From: [REDACTED]
To: [Norfolk Vanguard](#)
Cc: [Cawston PC](#)
Subject: Cawston Parish Council - Deadline 7 submission
Date: 02 May 2019 21:39:29
Attachments: [Cawston Parish Council - Deadline 7 submission - Written submission of oral case and update on progress of discussion with applicant.pdf](#)

Cawston Parish Council wishes to make this submission for Deadline 7. It also serves as our confirmation of oral evidence at the hearings on 24th April and the requested update of progress in our discussions with Vattenfall.

1. TRAFFIC AND TRANSPORT

CAWSTON HIGH STREET - INTERVENTION SCHEME
Scale 1:500

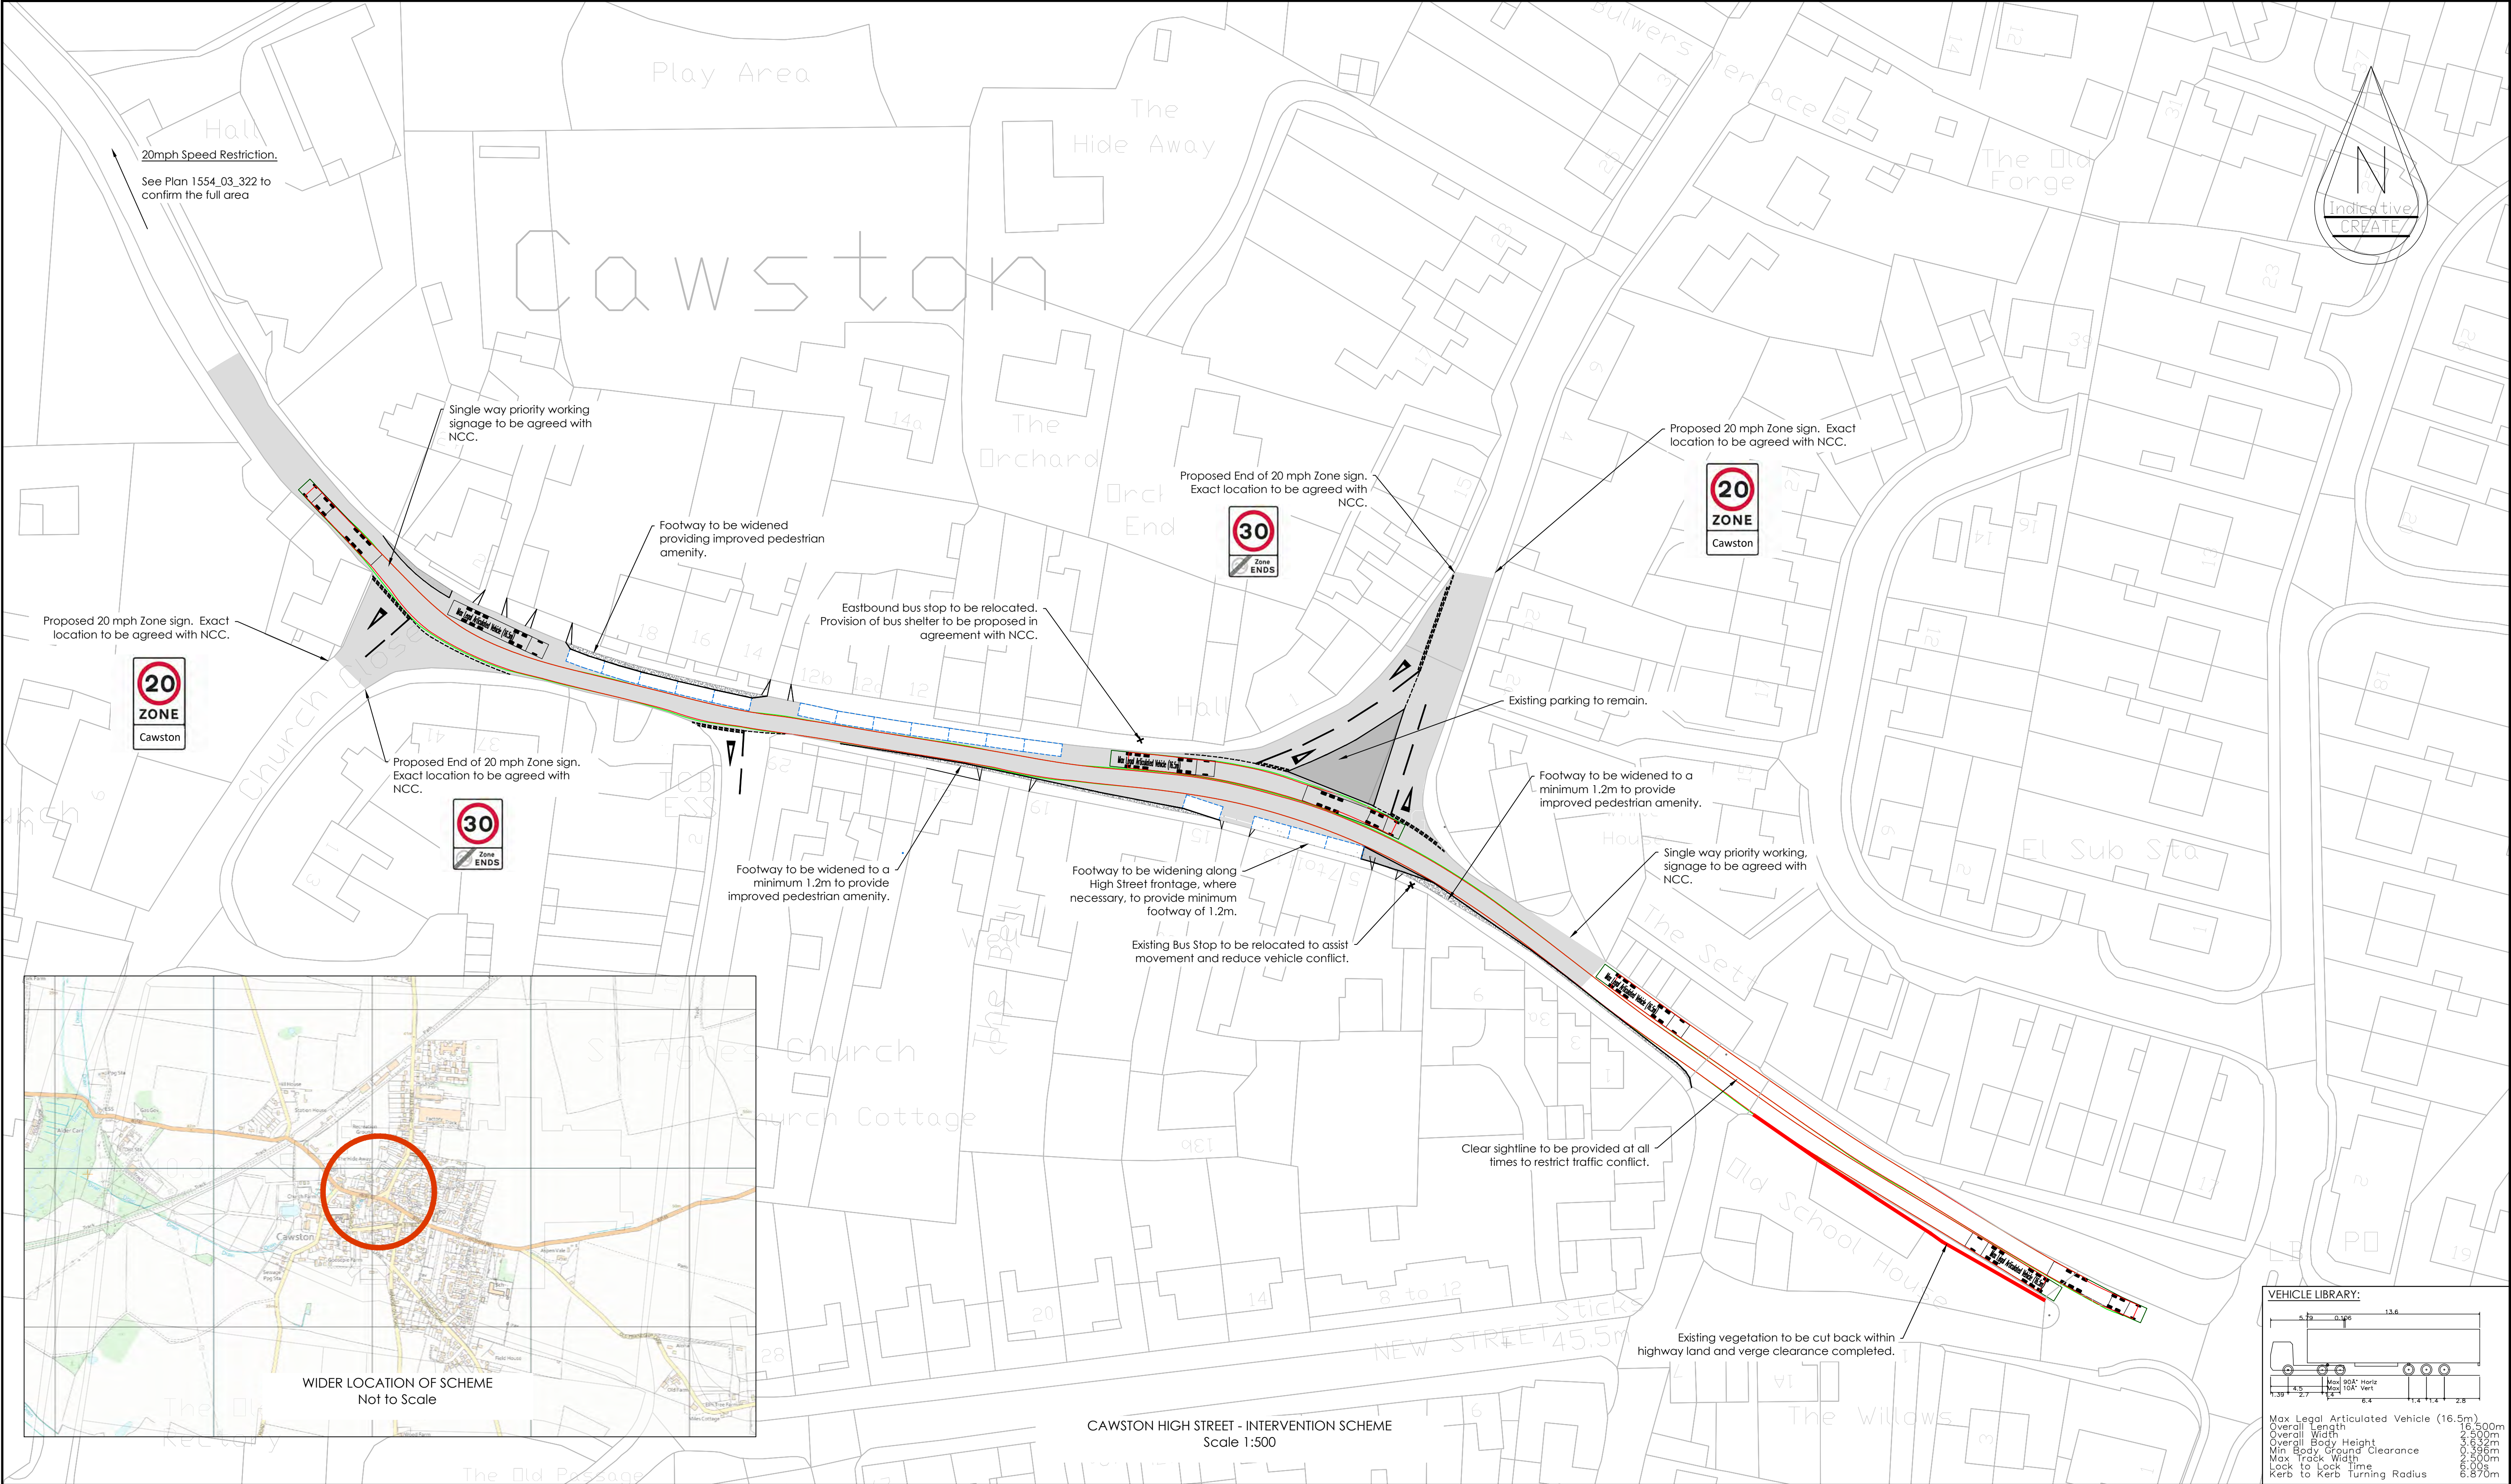
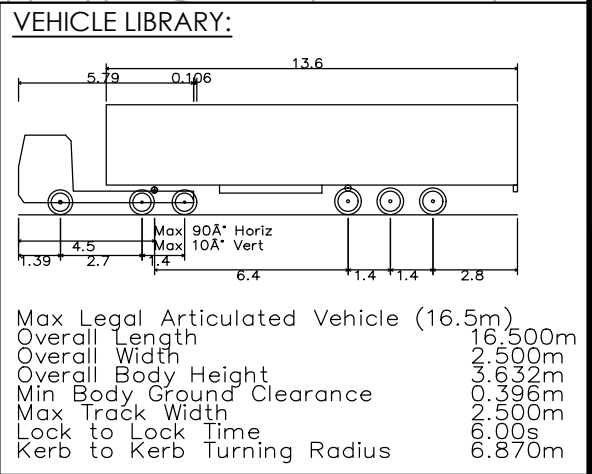
In Cawston, Vattenfall are still relying on the Orsted plan. This is already at v5 with no real progress. A Road Safety Audit has been done, but we only know this because there is a Norfolk County Council response on the Hornsea PINS site; the actual report itself has not been published there.

We have asked Orsted several times for a copy but it has not been provided. Vattenfall also claimed not to have a copy we could see. The Norfolk County Council response does give some clues to the content of this report; apparently it includes ... *"if just one car was to park badly, this could prevent a large vehicle manoeuvring successfully, resulting in an obstruction to the High Street"*.

The report also suggests that there is not room for the Orsted plan's proposed improvements to footpaths, and that parked cars provide some protection for pedestrians, but it then suggests that parking restrictions should be considered. This had been rejected in a previous version of the plan; it is going round in circles.

Even then, NCC generously suggest that a workable scheme can still be developed, though this one is not it. That is the quote that Vattenfall choose to pick out in isolation. CPC disagrees, Orsted have had months to come up with a scheme, have tried five times and have failed, for all the fundamental reasons previously discussed and demonstrated on the ASI.

NCC Highways is concerned with traffic flow, not residents' amenity; if you succeed in the former you fail in the latter. Broadland District Council, dealing with residential amenity, assumed that all proposed mitigation measures, including the use of Heydon Road, were necessary; we have already shown that the proposed traffic mitigation measures do not work.
